August 11, 2023  
Revised August 23, 2023

Reference: Engineering Services  
6983 US-401  
Fuquay-Varina, NC 27526  
TE&D Project No.: 2301-020783\_R

As requested, a representative of Tyndall Engineering & Design, PA (TE&D) was on-site to observe the following items per the home inspection report:

Level, BM1-3

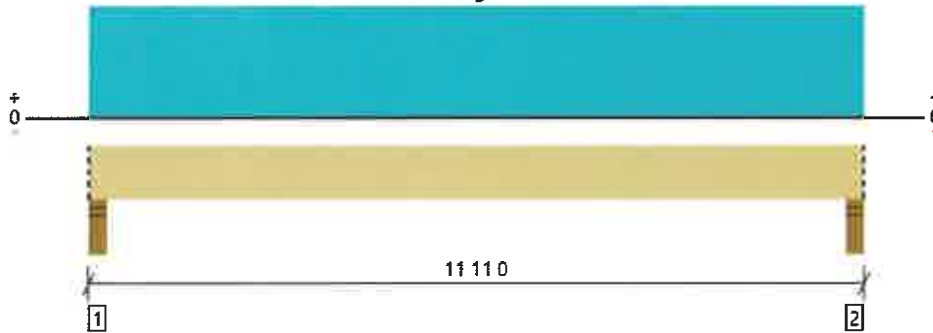
- c. A (3) 1-3/4" x 9-1/4" LVL header above the breakfast area supported by (4) 2 x 4 jacks at each end. Based on our observations and analysis, the current header is inadequate to support the anticipated loading conditions. TE&D recommends that the beam be enhanced to a minimum (4) 1-3/4" x 9-1/4" LVL beam supported at each end by a minimum of (5) 2 x 4 jacks.
